RE: Response to Submissions for Bulk Recovery Solutions, Ingleburn

The following outlines additional information and clarification to address the New South Wales (NSW) Environment Protection Authority (EPA) and Department of Planning & Environment (DP&E) submissions relating to the *Air Quality Impact Assessment Bulk Recovery Solutions, Ingleburn* (AQIA) (**Todoroski Air Sciences, 2018**).

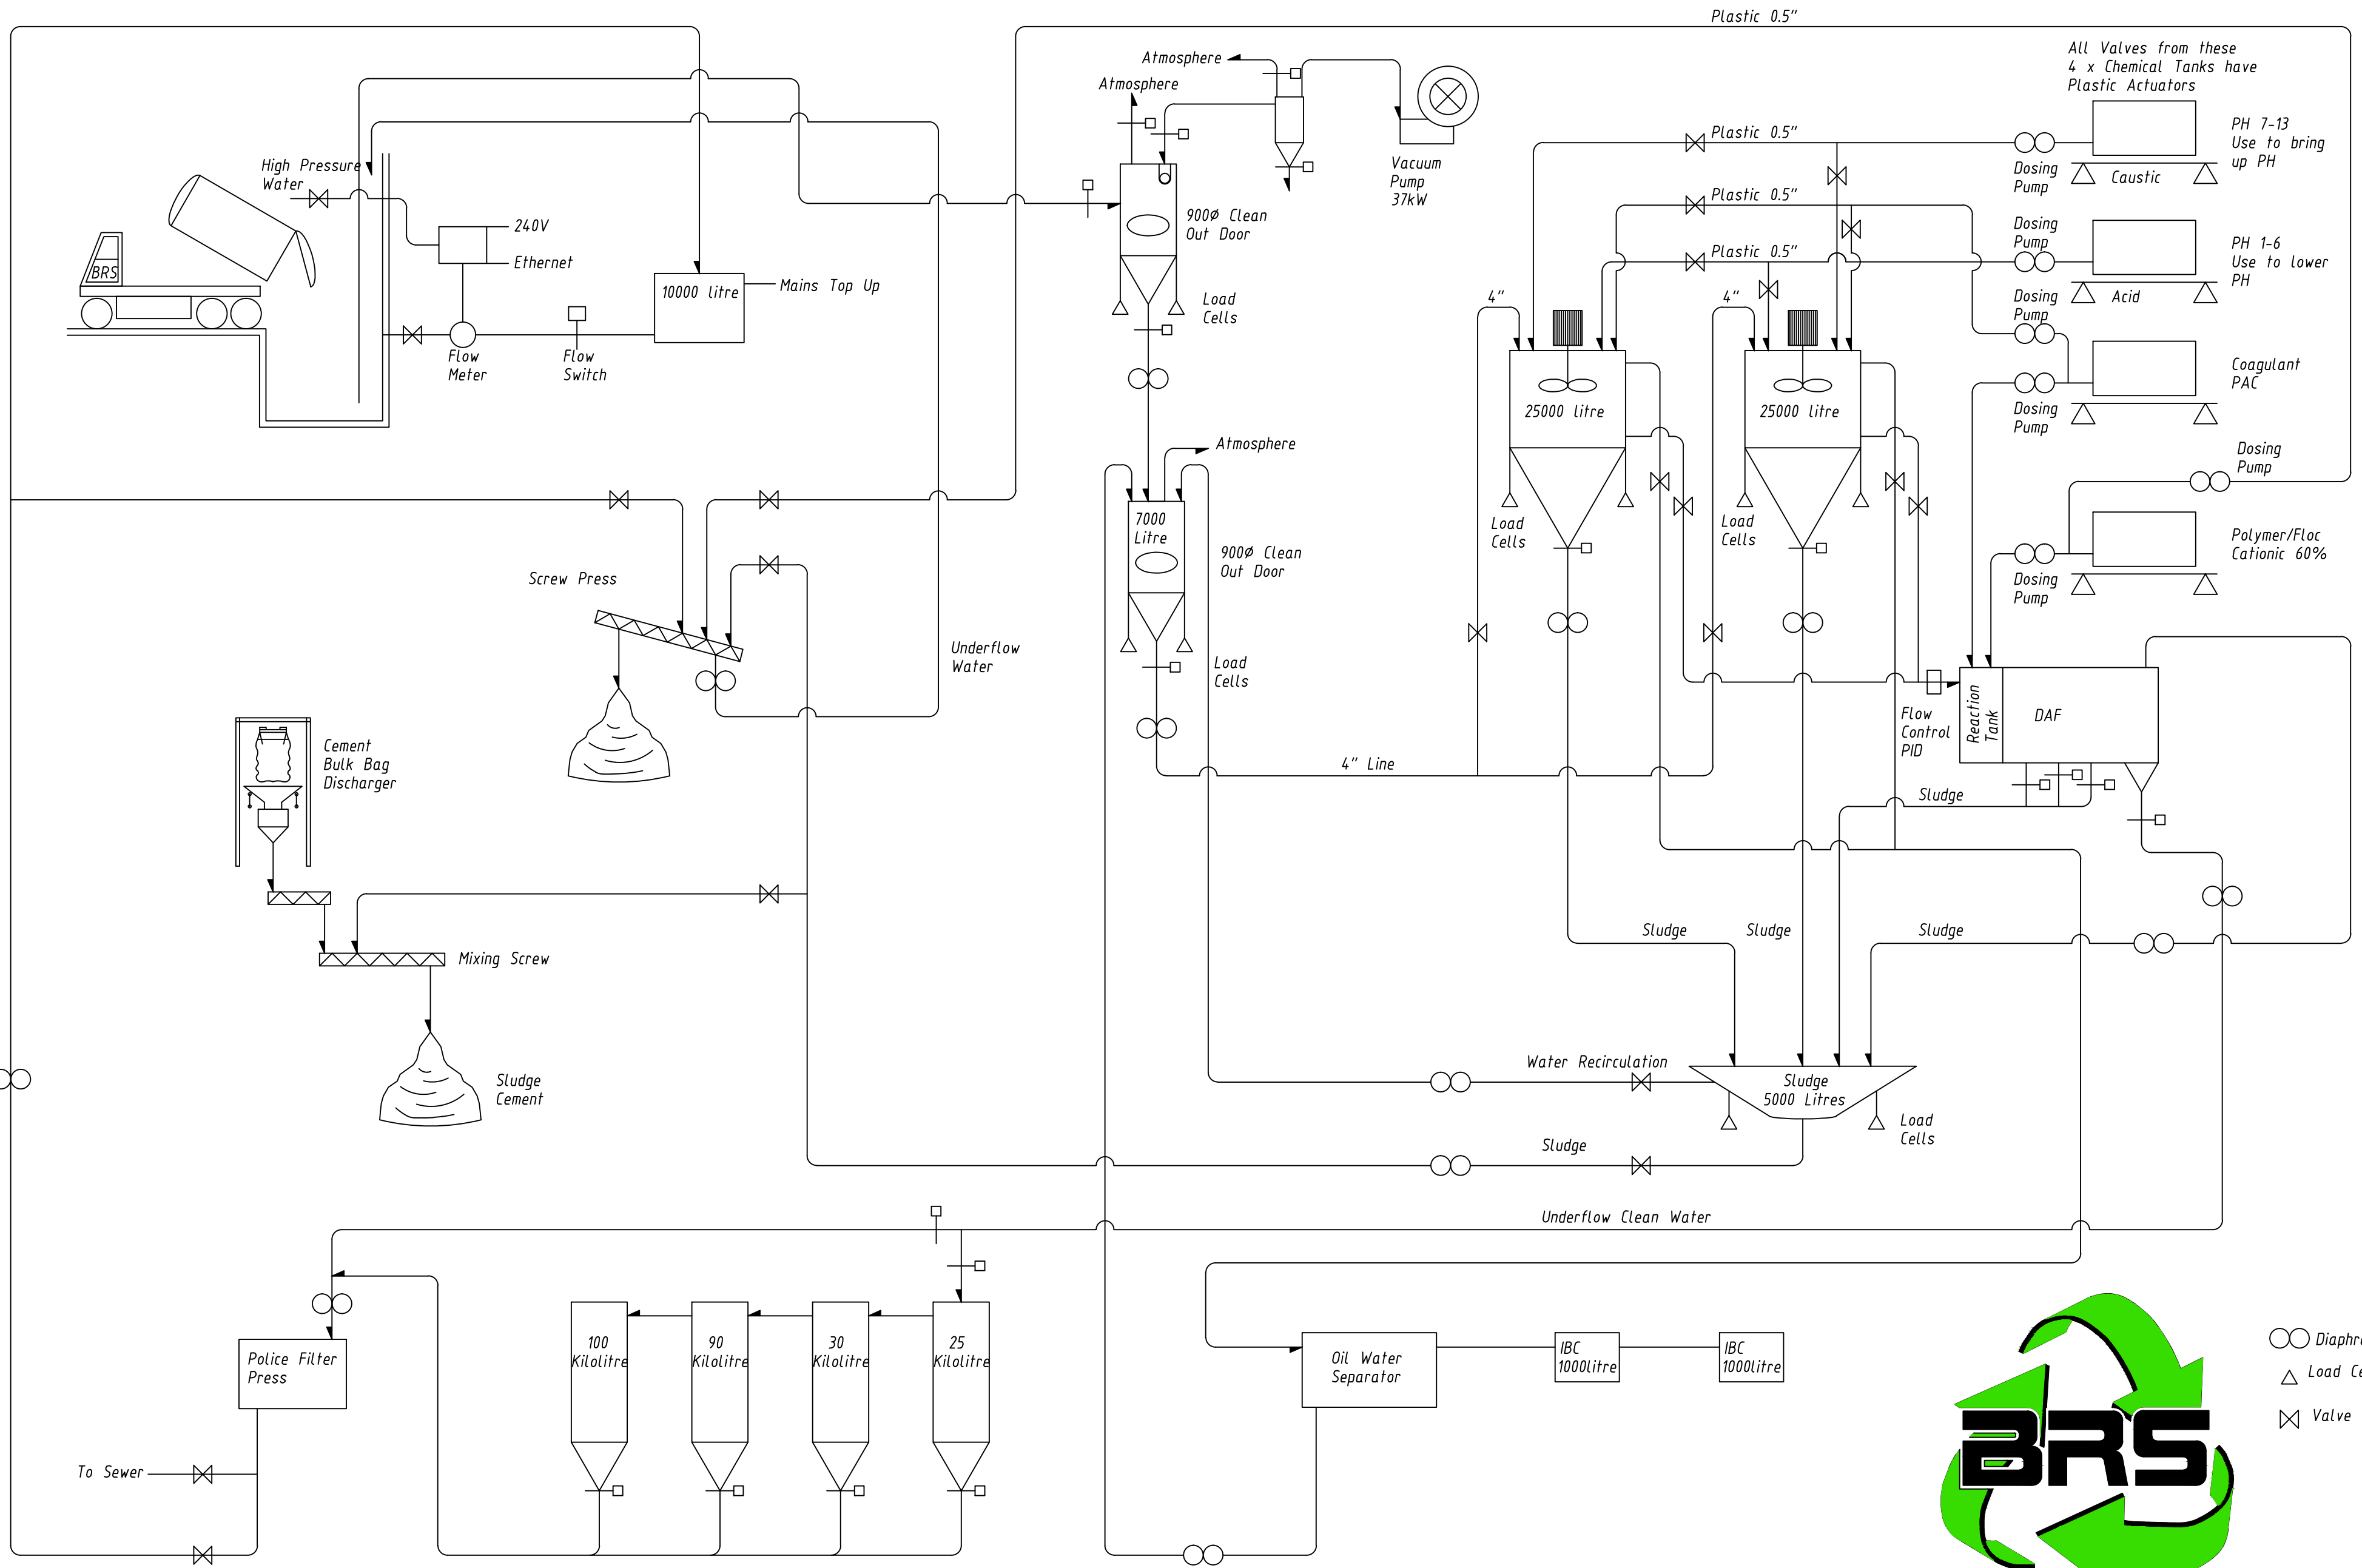
- i. *The only potential odour sources, identified in the AQIA for the proposal, are from the stockpiling of foundry sand from the dissolved air flotation (DAF) treatment of liquid waste and the DAF system. It is proposed to process waste types that may have odour generating potential such as sewage sludge, grease trap oil, industrial waste water and waste oil and these waste types should be considered in the assessment. Adequate justification for omitting all odour sources except for DAF and foundry sand has not been provided.*

- ii. *Mitigation measures proposed to minimise the generation of odour from the identified odour sources include blending foundry sand with other materials to dilute the material and the use of charcoal filters within the DAF process. However, the AQIA is lacking:*

- *Plans, process flow diagrams and descriptions that clearly identify and explain all pollution control equipment and techniques for all processes on the premises*

- *A description of all aspects of the air emissions control system, with particular regard to any fugitive emission capture systems (e.g. hooding, ducting), treatment systems (e.g. scrubbers, bag filters) and discharge systems (e.g. stacks)*

- *The operational parameters of all emission sources, including likely operational variability*
 - *It has not been established how the proposed mitigation measures will be used to effectively minimise emissions from all potential odour sources at the premises*

Liquid waste types including sewage sludge, grease trap oil, industrial waste water and waste oil which are proposed to be processed at the Project have been considered in the assessment.

The liquid wastes will be transported to site in vacuum sealed trucks and pumped directly from the trucks into sealed vacuum storage tanks located within the building enclosure for processing. The vacuum storage tanks will be fitted with carbon filters to treat the air ventilated during the filling of the tanks, and any such release occurs indoors. Overall, as the liquid wastes are not directly exposed to the air, and any emissions are treated with a carbon filter, there is no potential for significant odour emissions to arise.

A flow diagram showing the liquid waste process at the Project is presented in **Figure 1**. We note the treatment of drilling mud and muddy waters are also treated in the same liquid waste process. This liquid material is unloaded to a pit for collection and processing as shown in **Figure 1**.
